Re: Response to Submissions for SSD7521 - North Plot and Square

In response to the Department of Planning & Environment and The Sydney City Council's letters on the SSDA submission for the North Plot and Square at Darling Square, we note the following to be addressed;

Lendlease Design Mechanical Services Response:

TITLE
FLOOR PLAN LEVEL 05
DWG NO.
ADP07

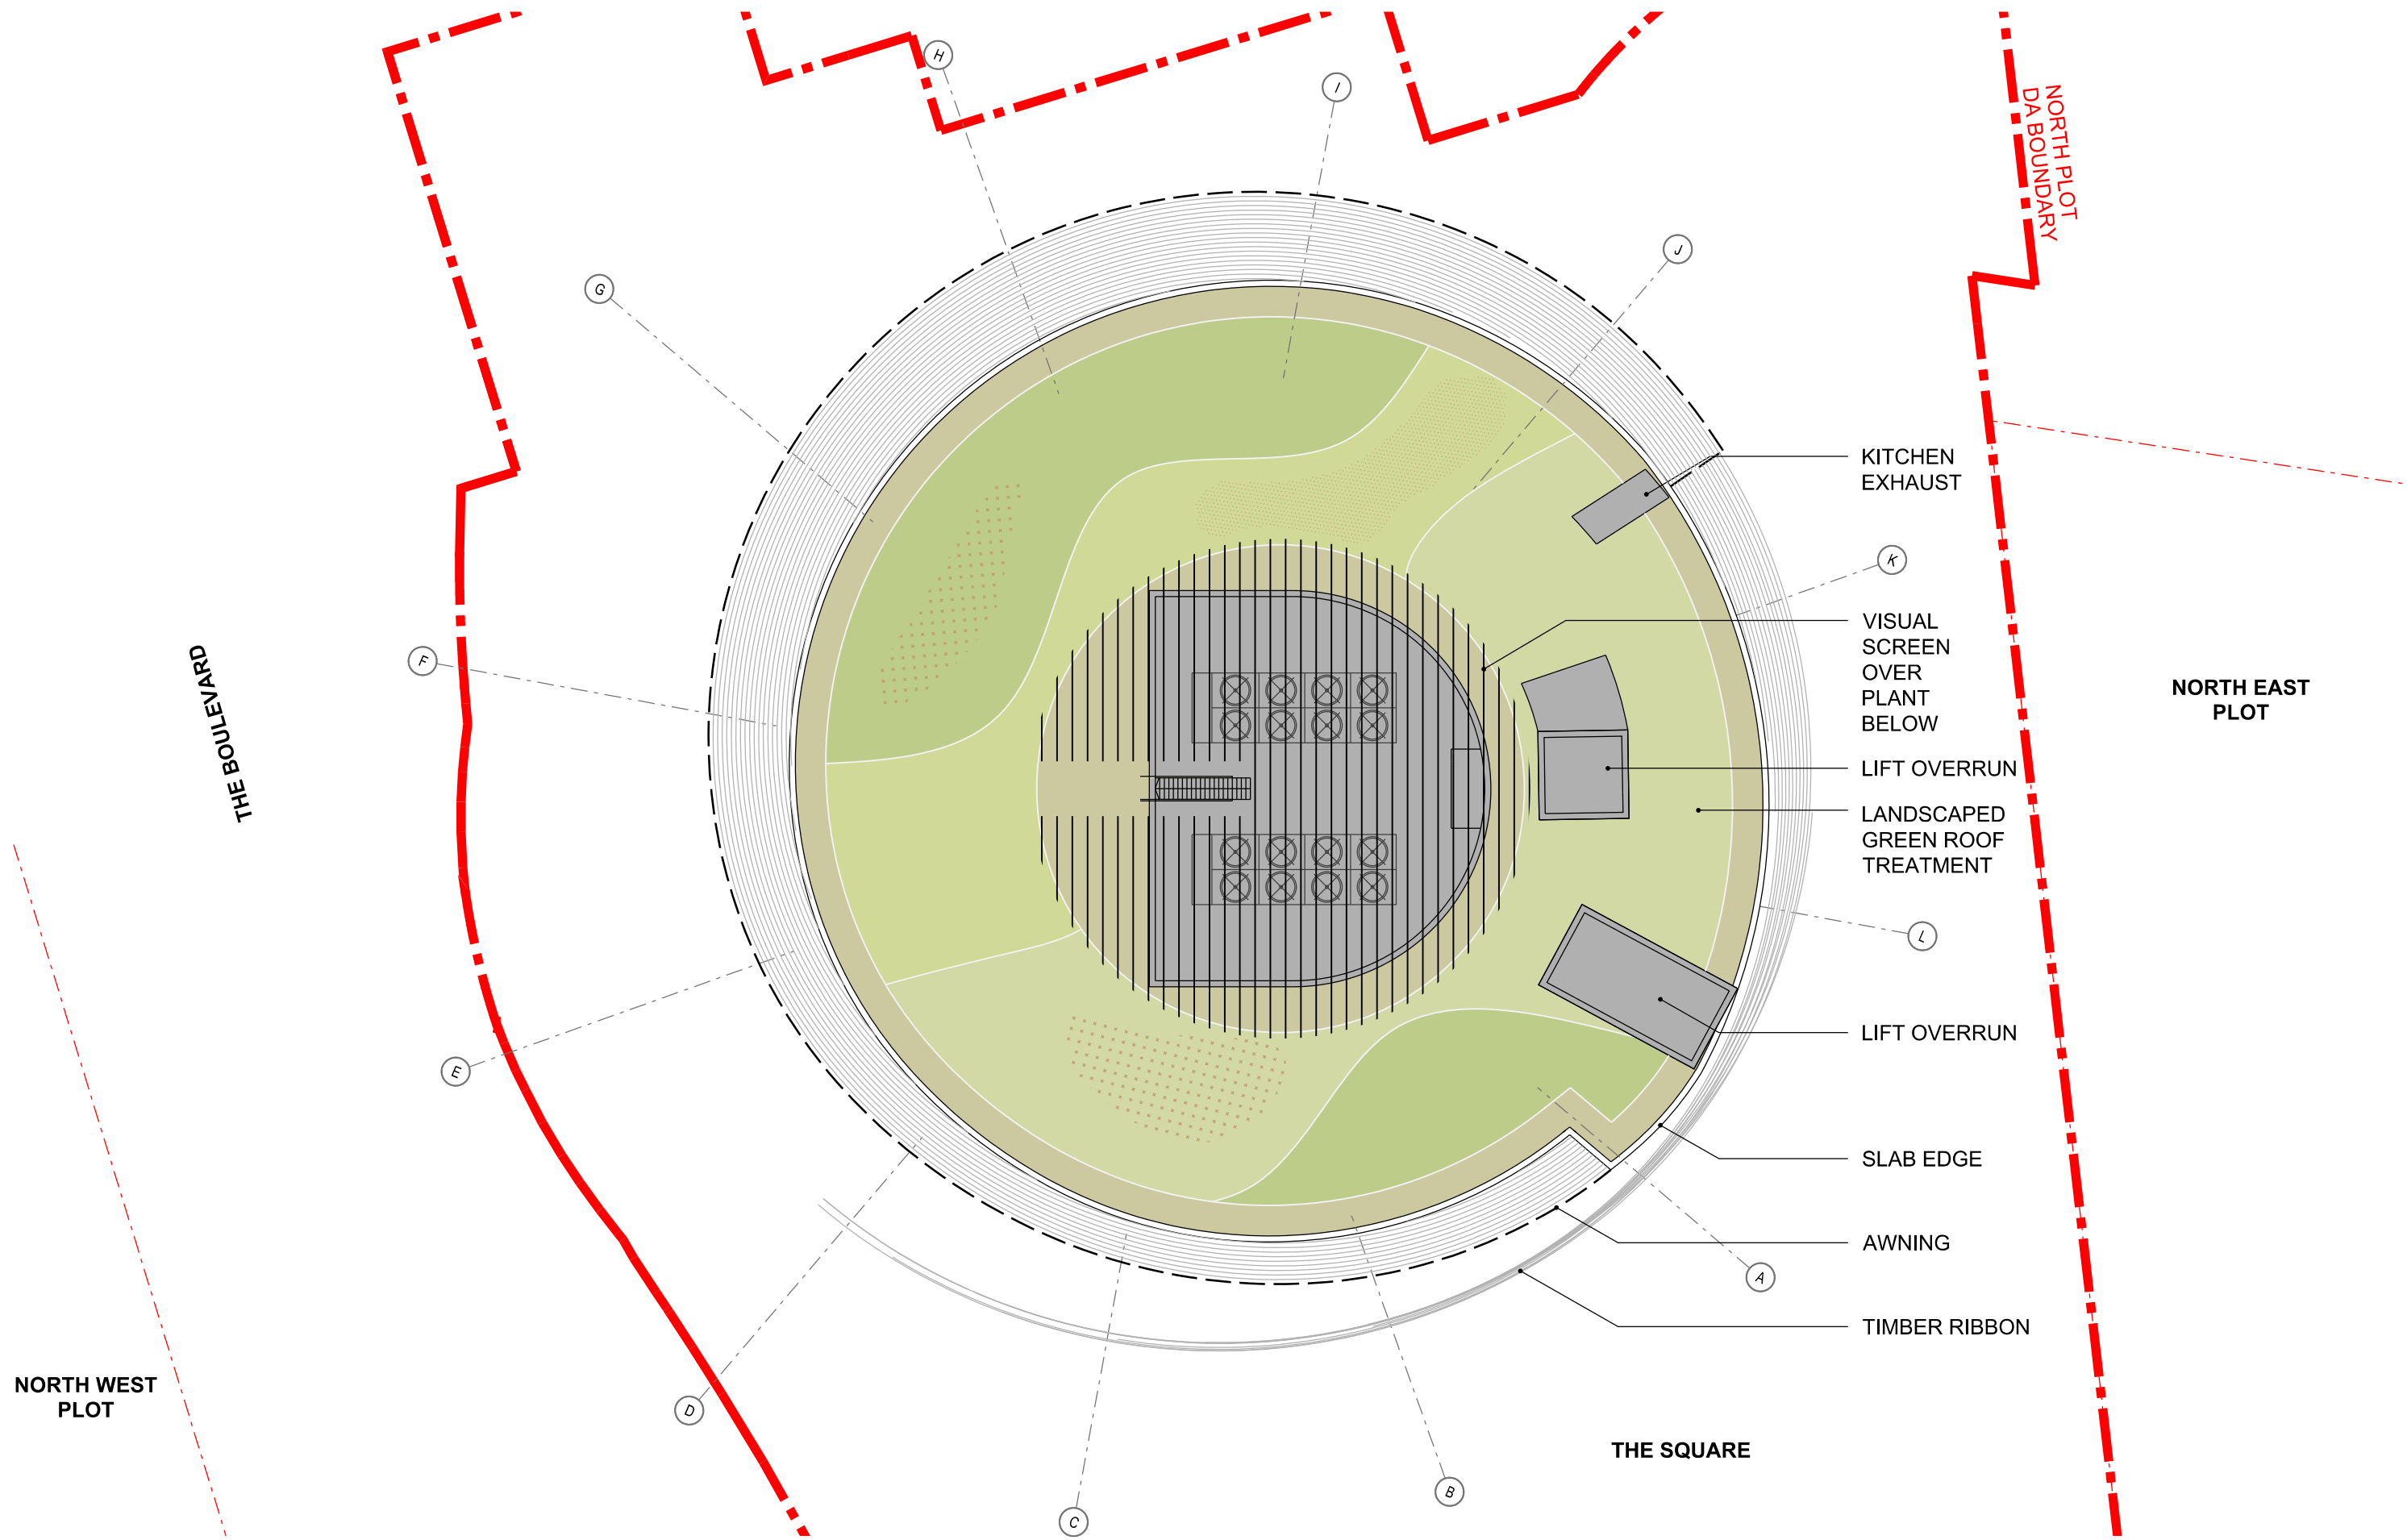
To avoid future adverse air quality discharge from retail tenancies, including animal fats, grease, smoke and odours, the Applicant should be requested to determine the targeted mechanical capacities of the retail tenancies and their discharge. The design or limitations of mechanical systems may determine how retail spaces are occupied or where a discharge point may be required. This is especially so given the recent popularity of charcoal, wood fire and other solid fuel cooking methods.

Table 3 – Level 5 Bar/Restaurant Kitchen Exhaust Provisions

Tenancy No.	Tenancy Type	Tenancy Area (m ²)	Standard K/E Provision (L/s)	Charcoal K/E Provision (L/s)	K/E Make-Up (L/s)
L05	Food & Beverage	130	3,500	1,500	4,000
		130 m2	3,500 L/s	1,500 L/s	4,000 L/s

Adverse air quality discharge from retail tenancies has also been addressed through the incorporation of exhaust discharge treatment systems. Individual tenancies shall be required to install exhaust canopies complete with electrostatic precipitation (ESP) filters, UV lamps and ozone generation and charcoal filtration. Kitchen exhaust systems shall discharge vertically at roof level in compliance with AS1668.2-2012.
